City of Portland, Maine – Building or Use Permit Application 389 Congress Street, 04101, Tel: (207) 874-8703, FAX: 874-8716

Location of Construction: * 30 Dayton Street, 04103		Owner: Charles & Janice Shannon *		Phone: 797-6058		Permit No: 000488
Owner Address: 30 Dayton Street, 04103		Lessee/Buyer's Name:		Phone:		
Contractor Name: Scott Proctor		Address:		Phone:		Zone: R-3 CBL: 339-C-015 Zoning Approval: OK - 5/16/00 Special Zone or Reviews: <input type="checkbox"/> Shoreland N/A <input type="checkbox"/> Wetland <input type="checkbox"/> Flood Zone <input type="checkbox"/> Subdivision <input type="checkbox"/> Site Plan maj <input type="checkbox"/> minor <input type="checkbox"/> mm <input type="checkbox"/>
Past Use: Single family dwelling		Proposed Use: SAME		COST OF WORK: \$ 3,000.00		
Proposed Project Description: Building 31' x 23 1/2' deck- wrapped around rear side of house.		Signature:		FIRE DEPT. <input type="checkbox"/> Approved <input type="checkbox"/> Denied		INSPECTION: Use Group R-3 Type 5B BOCA 99 Signature: <i>[Signature]</i>

BUILDING PERMIT REPORT

DATE: 10 MAY 2000 ADDRESS: 30 Dayton ST. CBL: 339-C-015
REASON FOR PERMIT: 6 1/2' x 21' deck 5' x 31' deck
BUILDING OWN

**CERTIFICATION
PLAN FOR
SLIN MORTGAGE.**

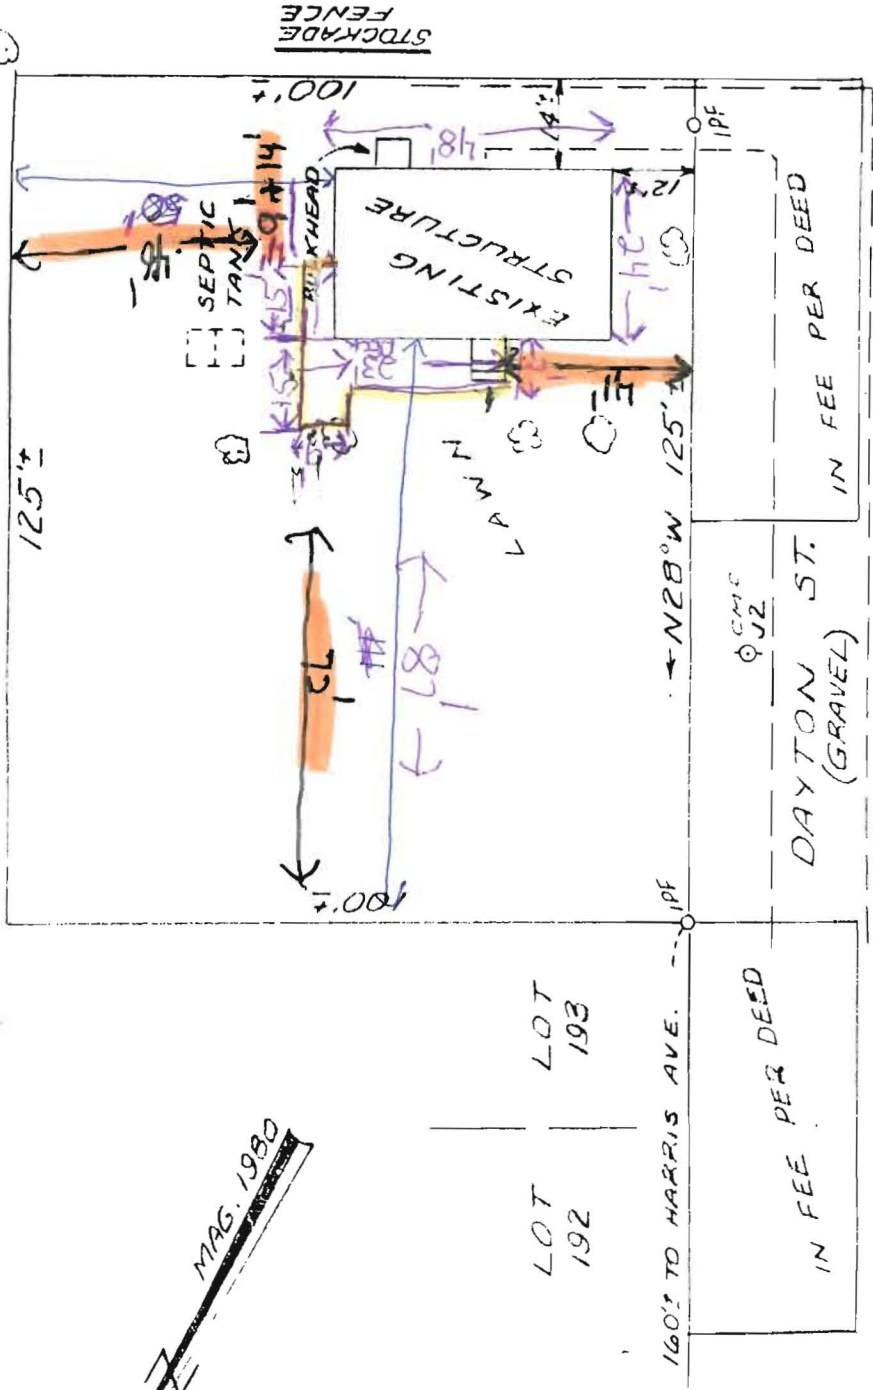
5/9/00
Deck not shown on plot plan

R-3 Zone
 front: 25' req - 41' shown
 sides: 8' req (1 story) - 14' + 80' shown
 rear: 25' req - 2 x 35' + 8' shown
 where the Decks
 OK
 5/16/00

Received updated
drawing 5/14/00

Plot Plan

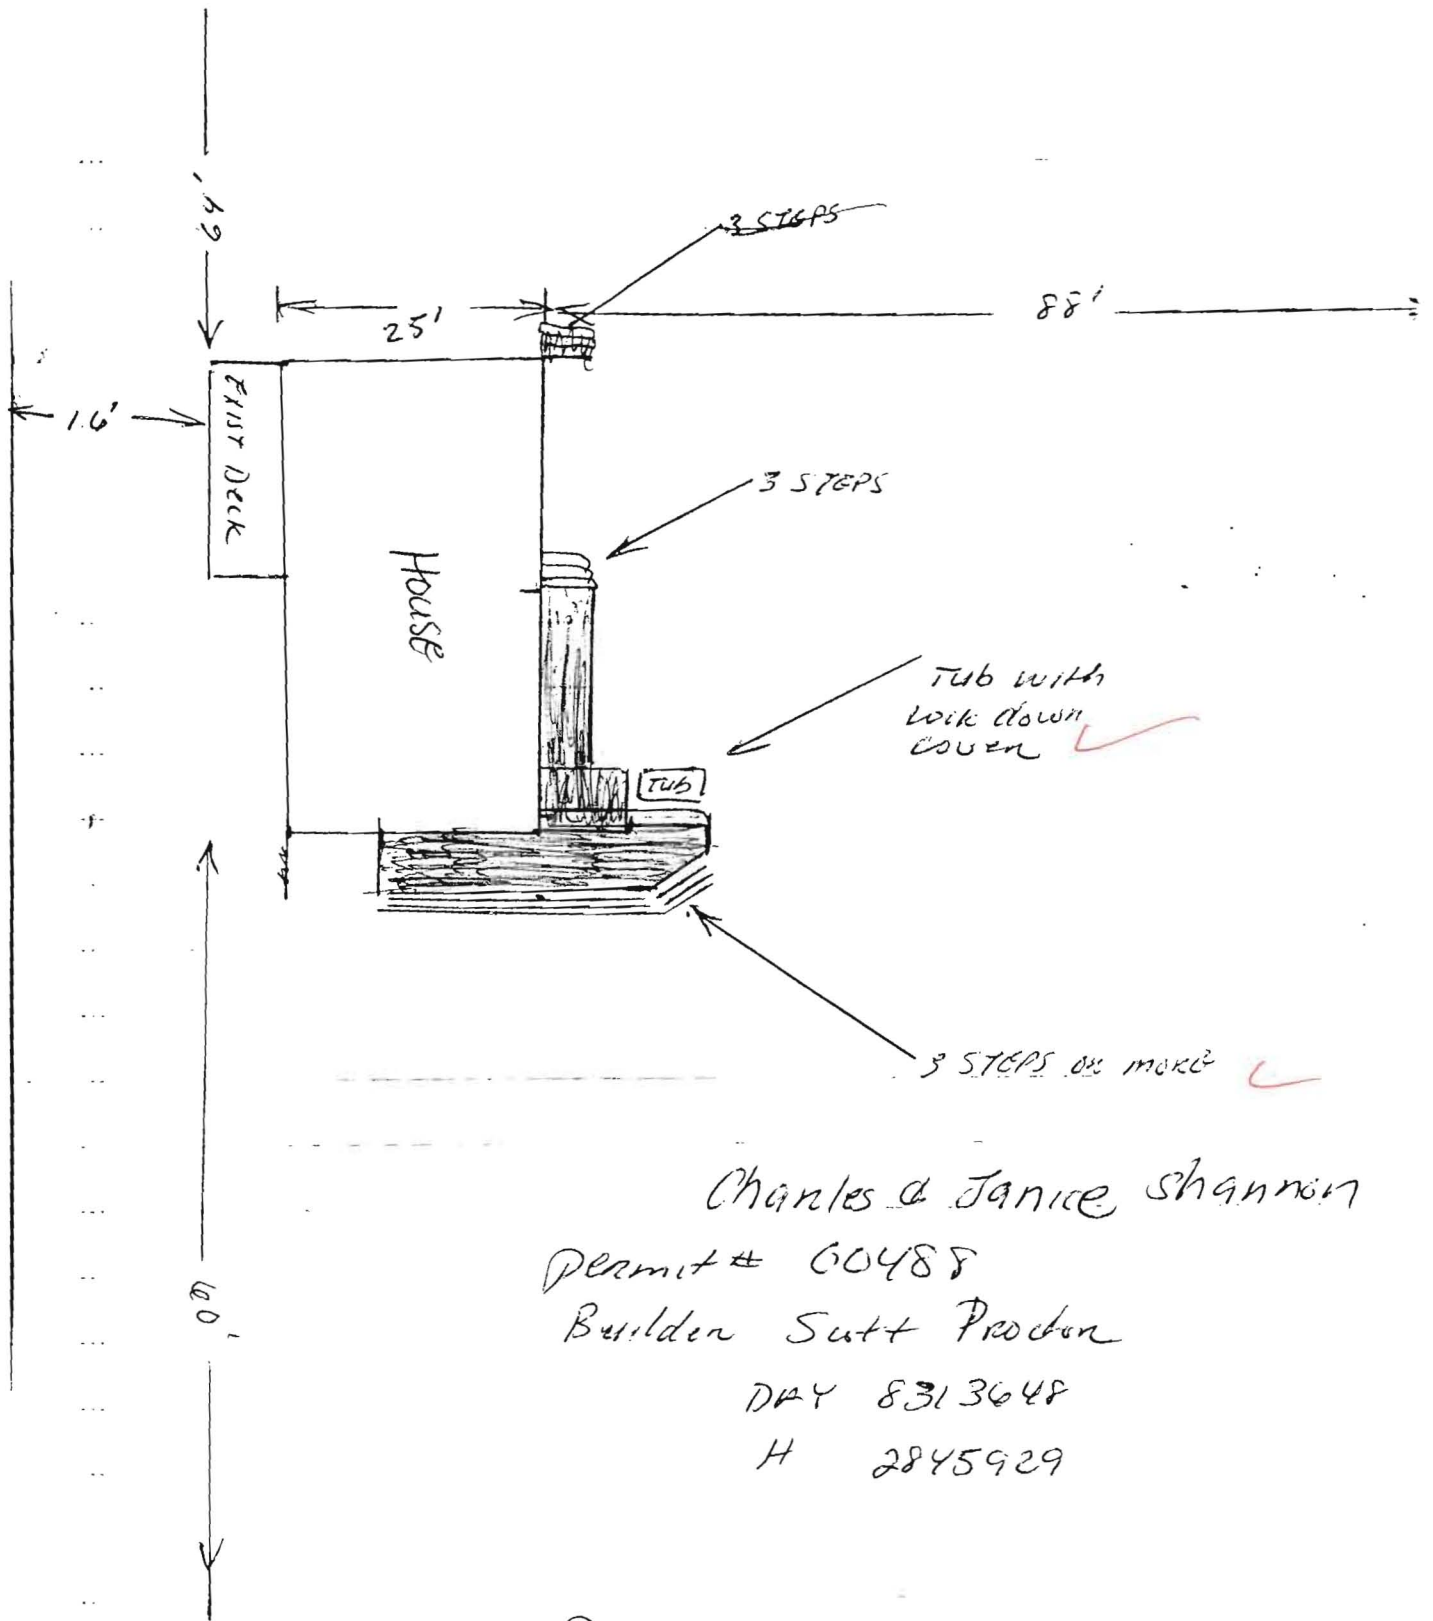
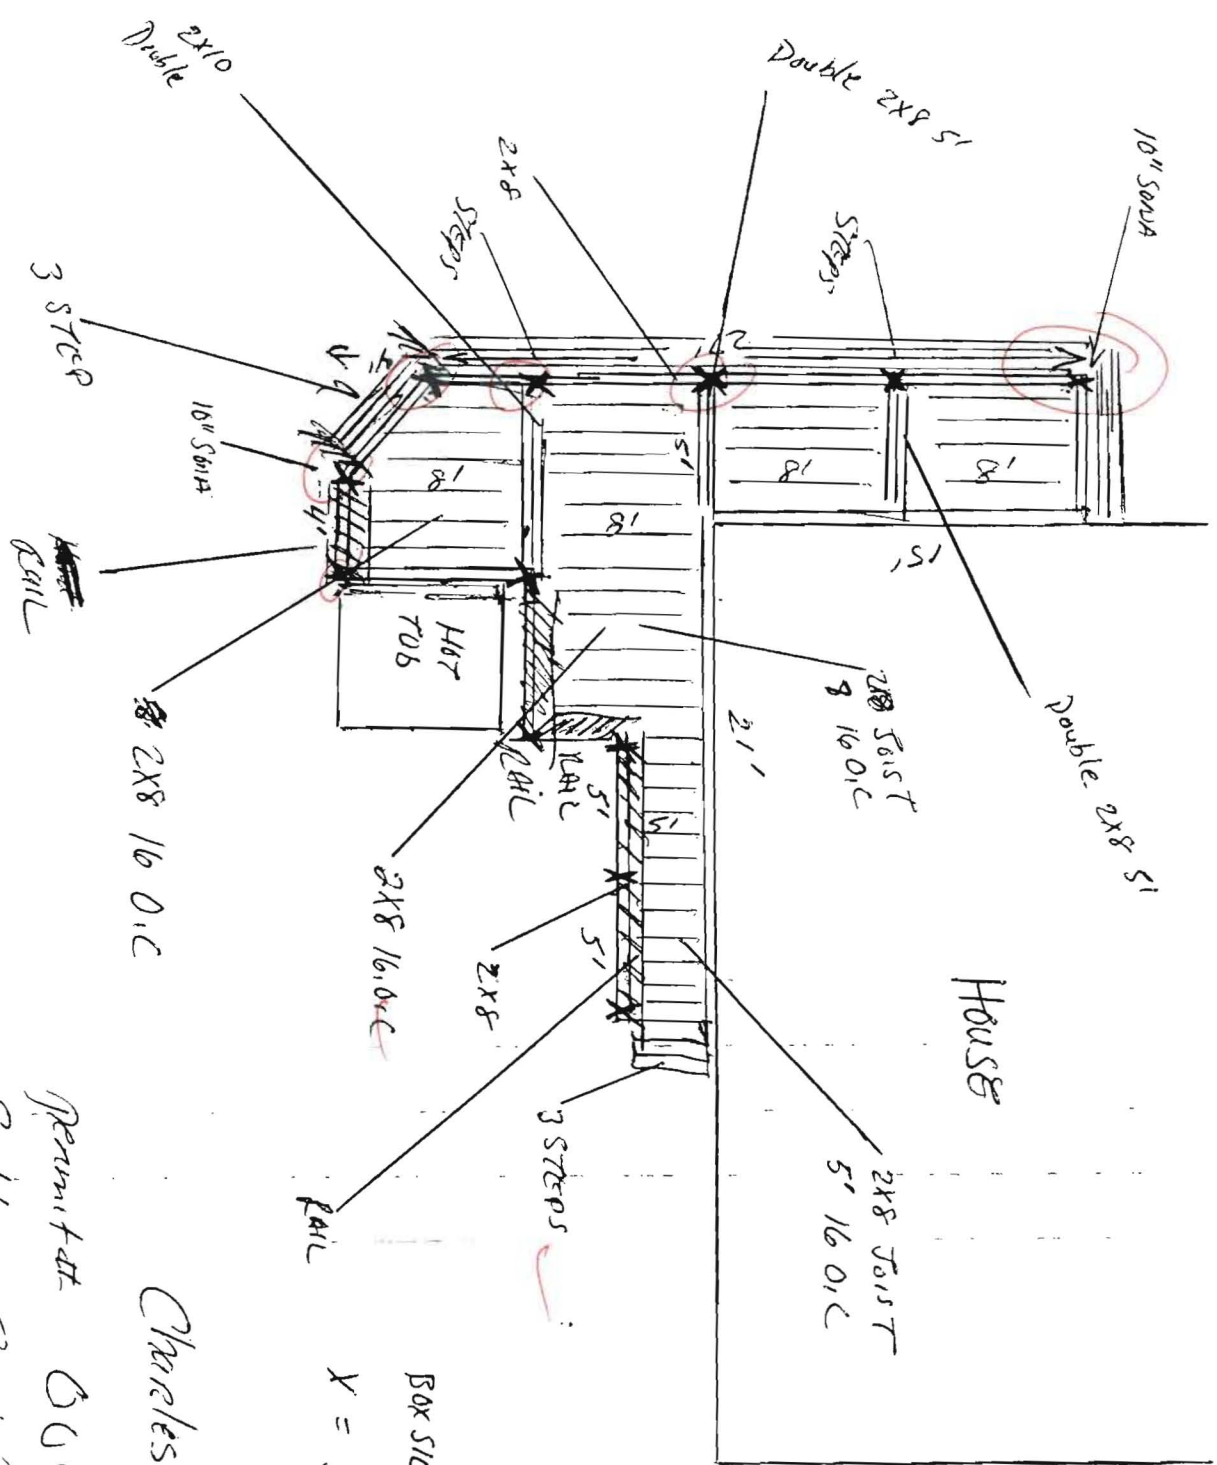
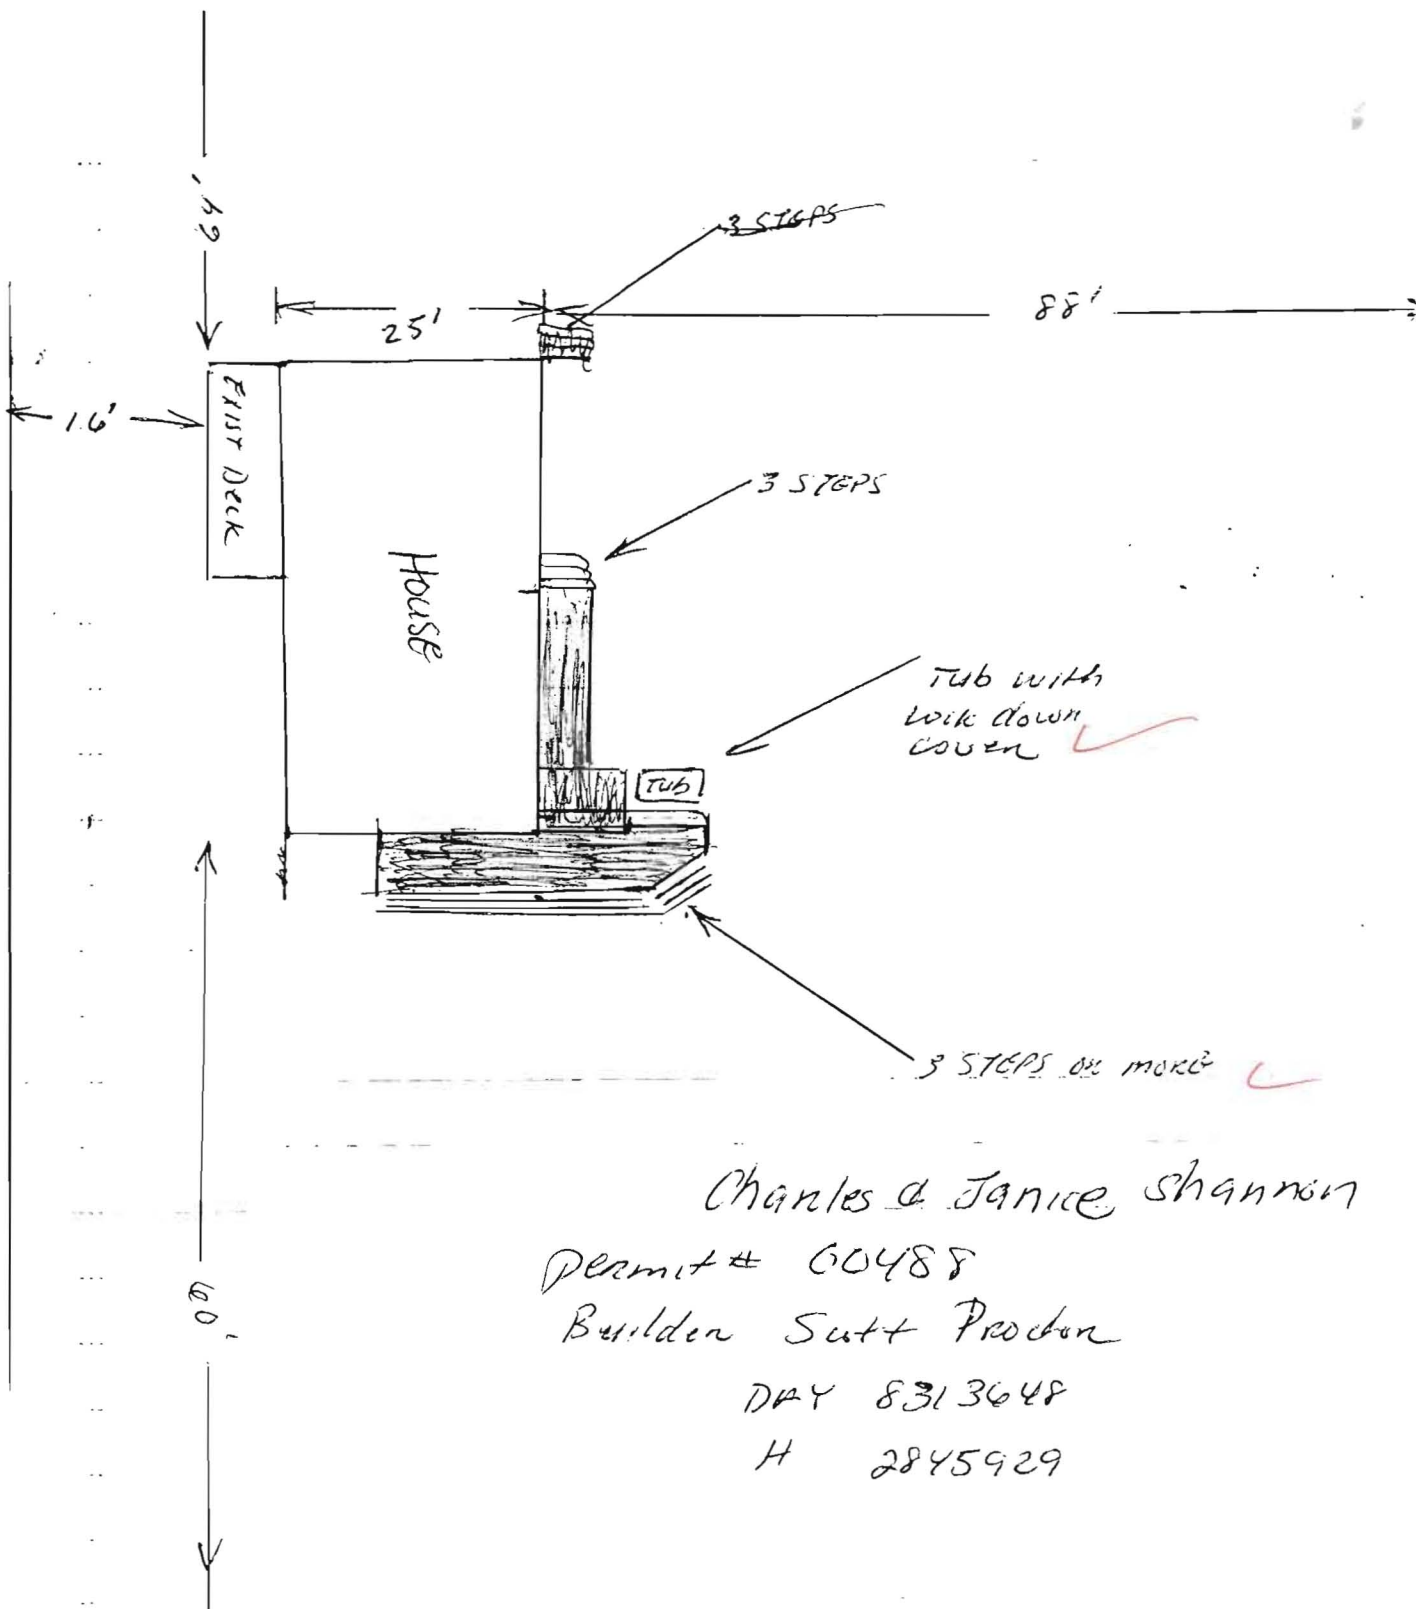
X 36. This permit is being issued with the understanding that before any work is started that a Framing detail be submitted to me for approval - your plans did NOT show the Foundation or Framing.

- 2 steps down drainage See report
 - 1" space from deck to house not affixed
 - Height from ground up - 27-28"
- 8' Sonotube 4'
 2x8 Joists
 4x4 post.
 as per owner
 11 MAY 2K
- = 1"
